Our Ref: WA/25/17/CLP
Your Ref:

Application for Lawful Development Certificate for a Proposed Use or Development

Development Lawful development certificate for the proposed use of first floor of existing garage/outbuilding as a holiday let.

Location Little Box Cottage Walberton Green Arundel

FRONT ELEVATION

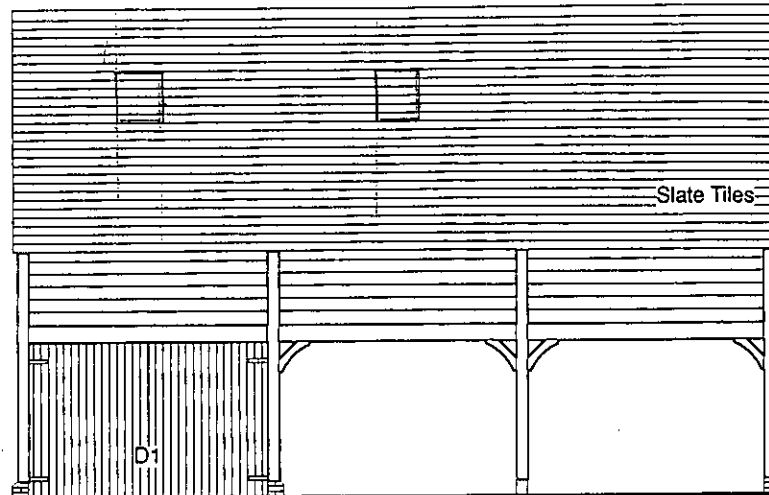
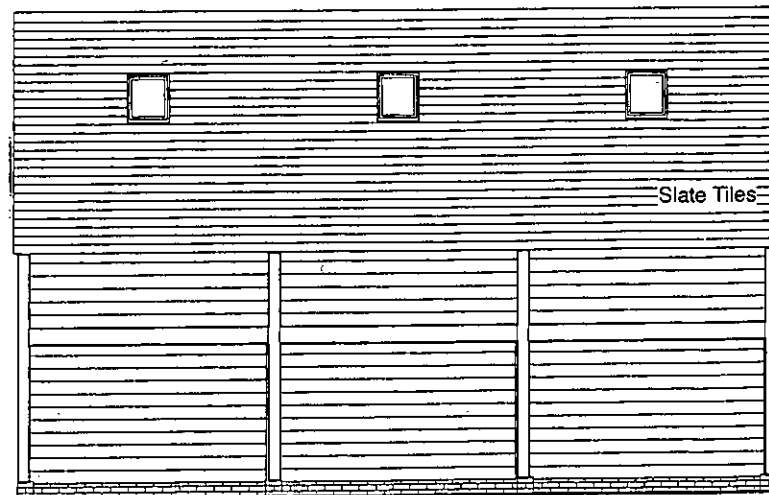
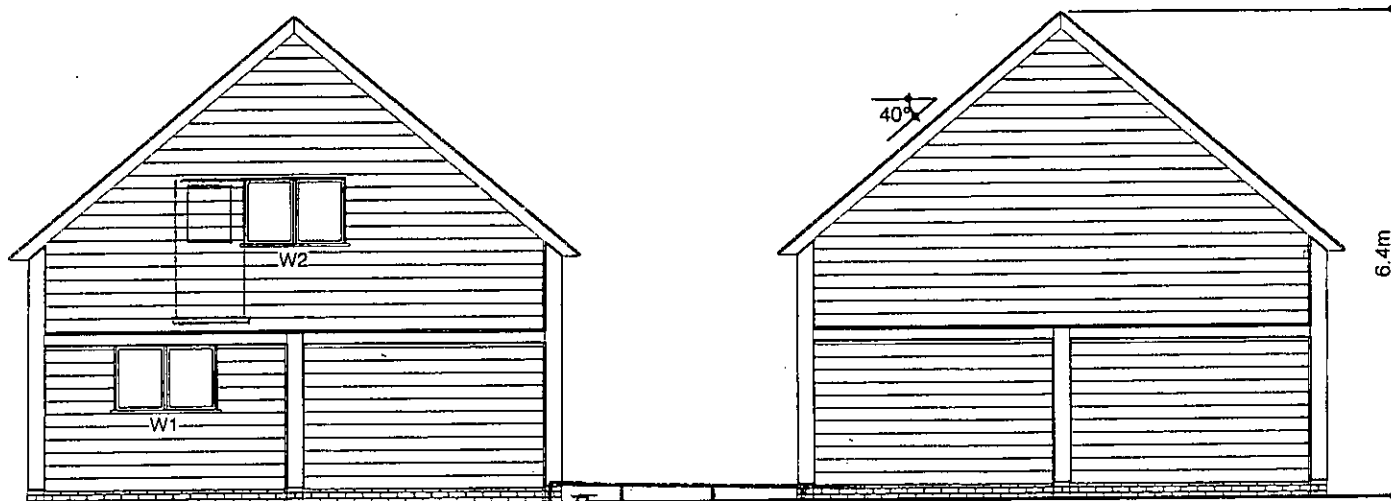
Please provide 3 copies of the existing and proposed elevations. If there is no change you may label the elevations as both 'existing and proposed'.

FIRST FLOOR PLAN

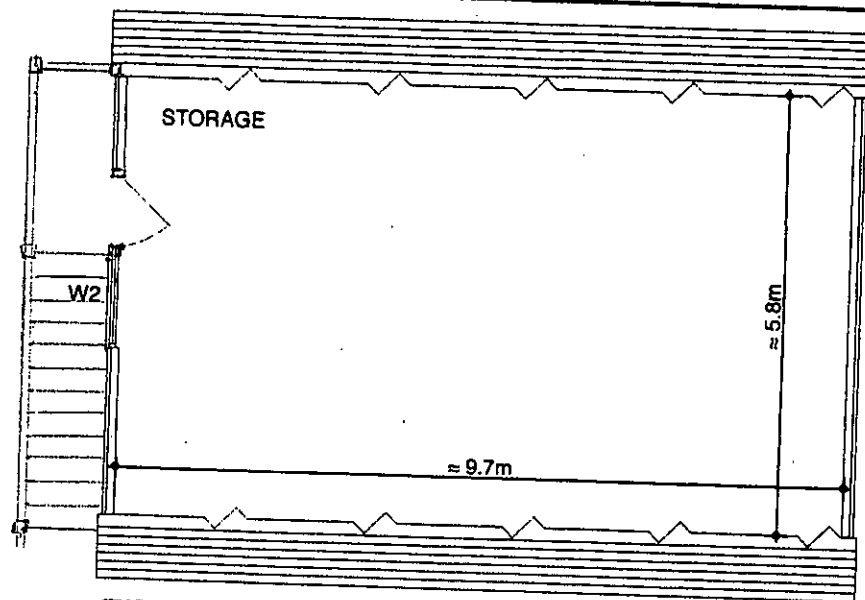
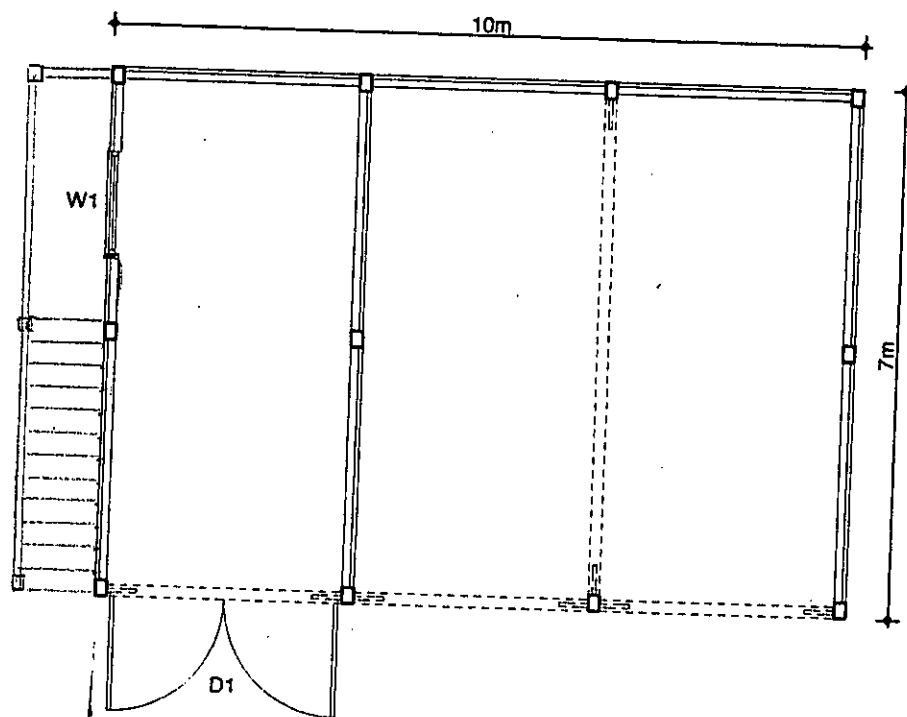
Please provide 3 copies of the existing and proposed floor plans. If there is no change you may label the floor plans as both 'existing and proposed'.

LOCATION & BLOCK PLAN

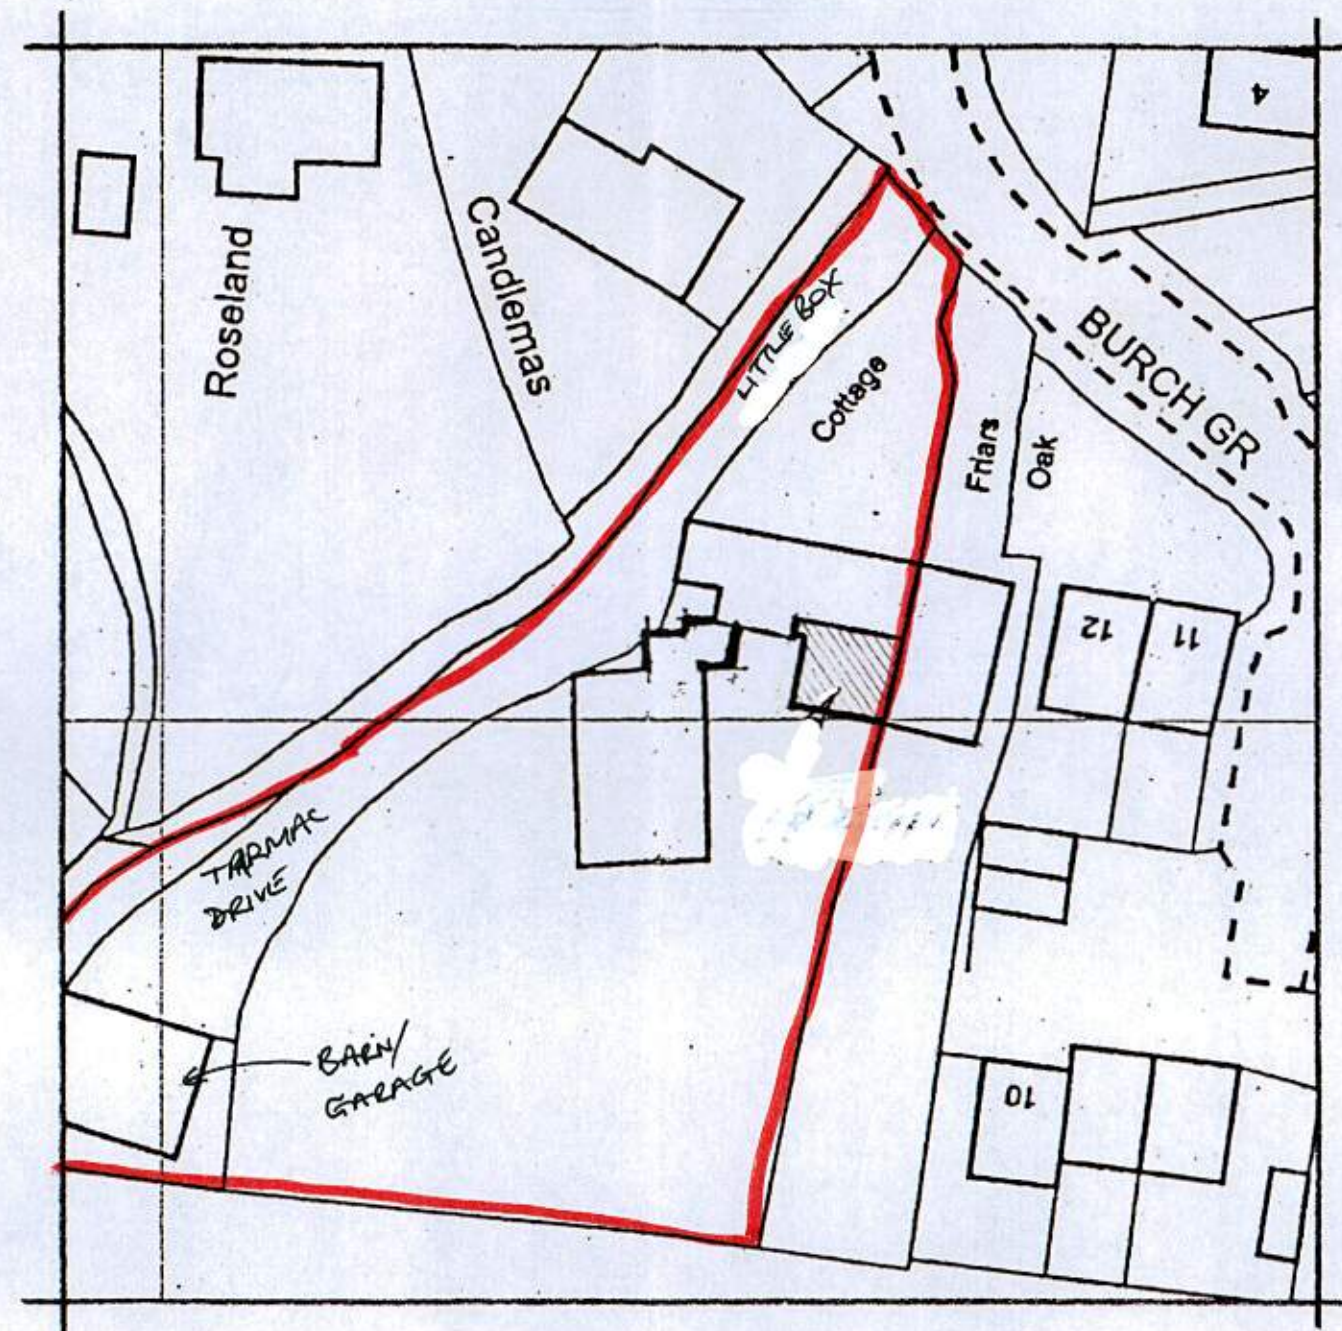
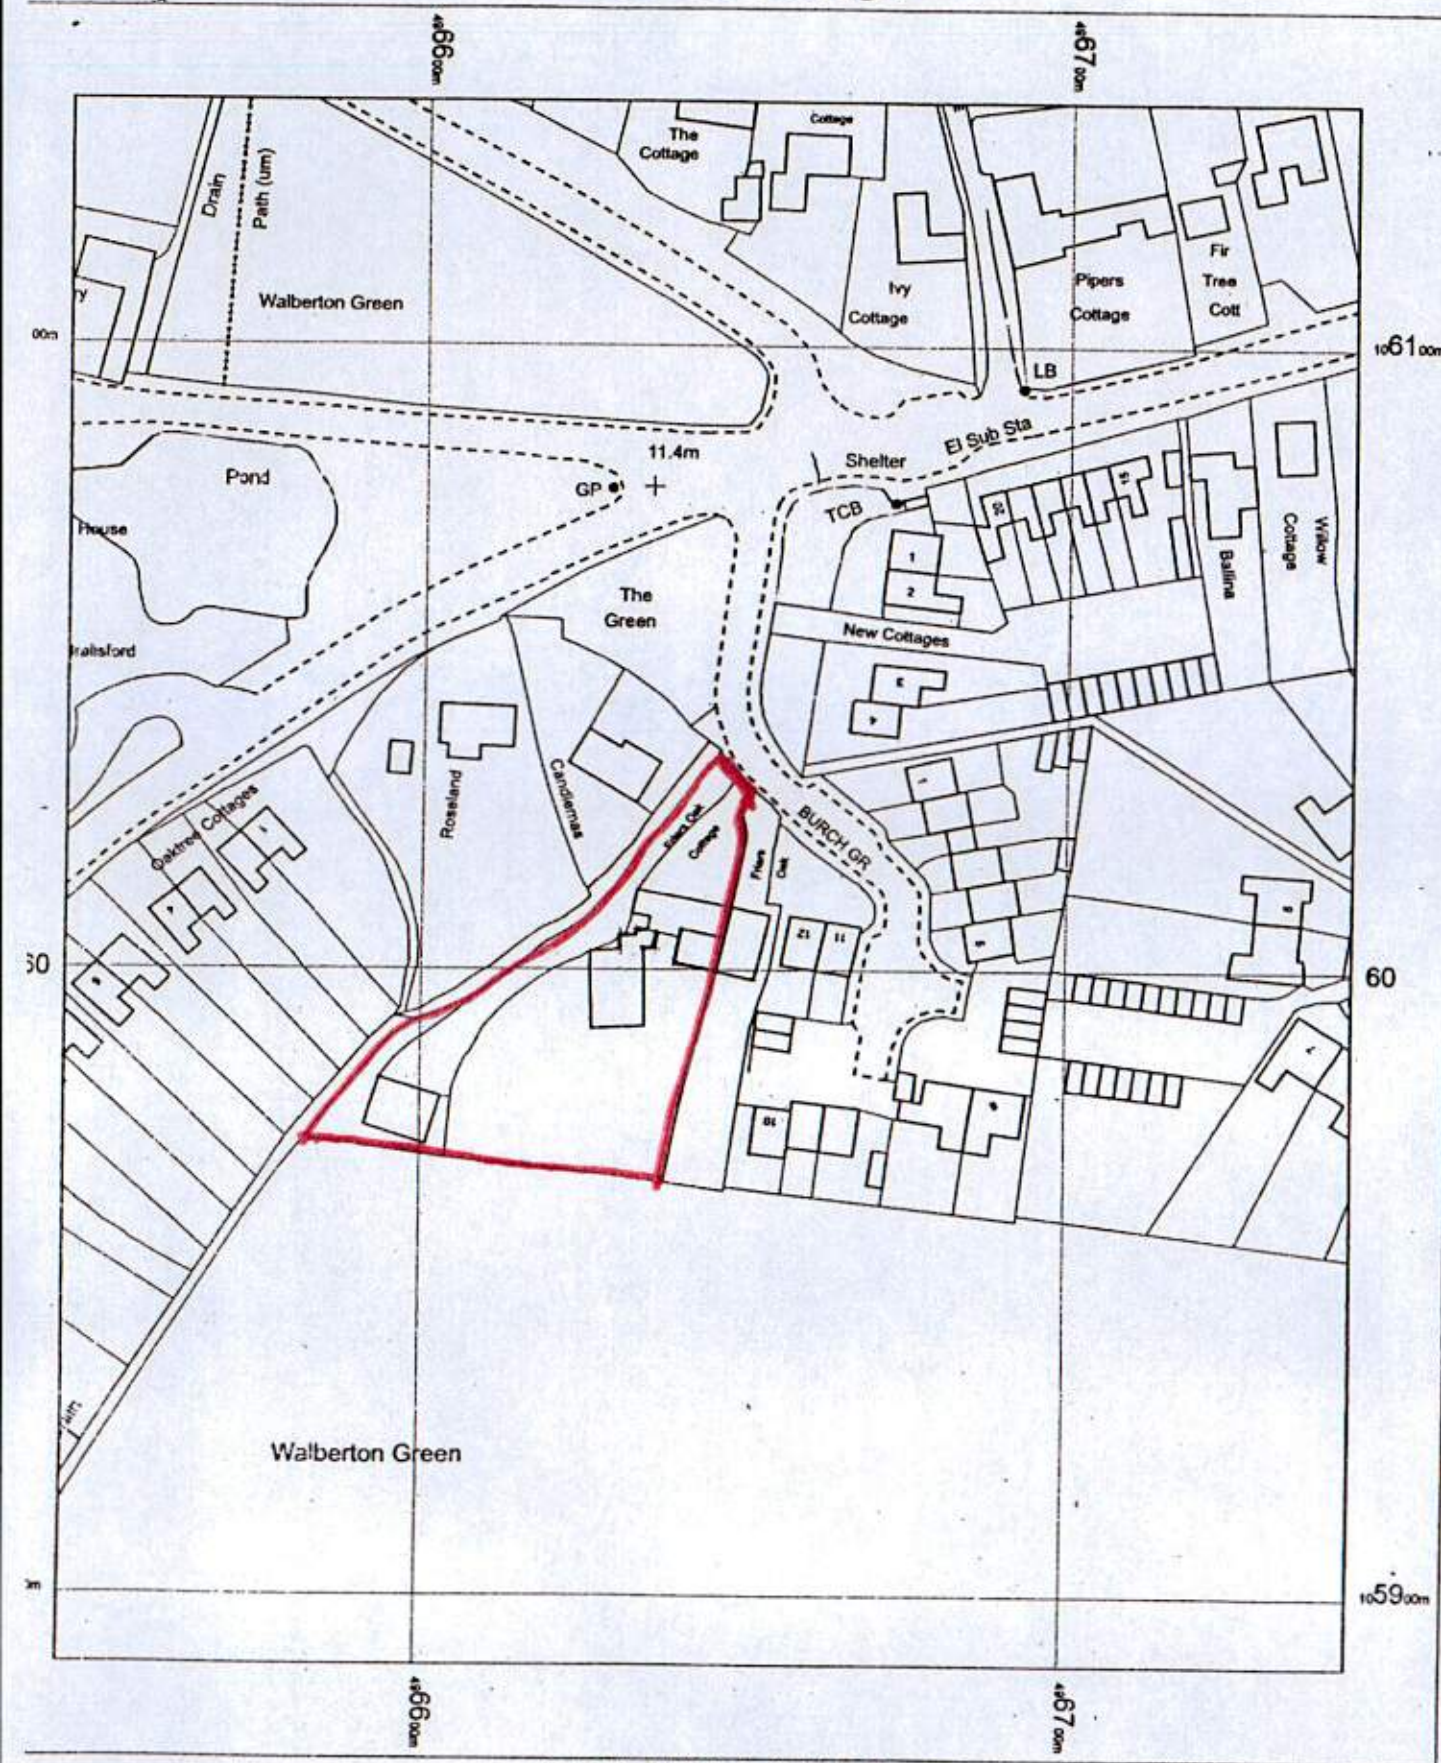
The location and block plan do not scale correctly. Please amend accordingly and return 3 copies to this office.
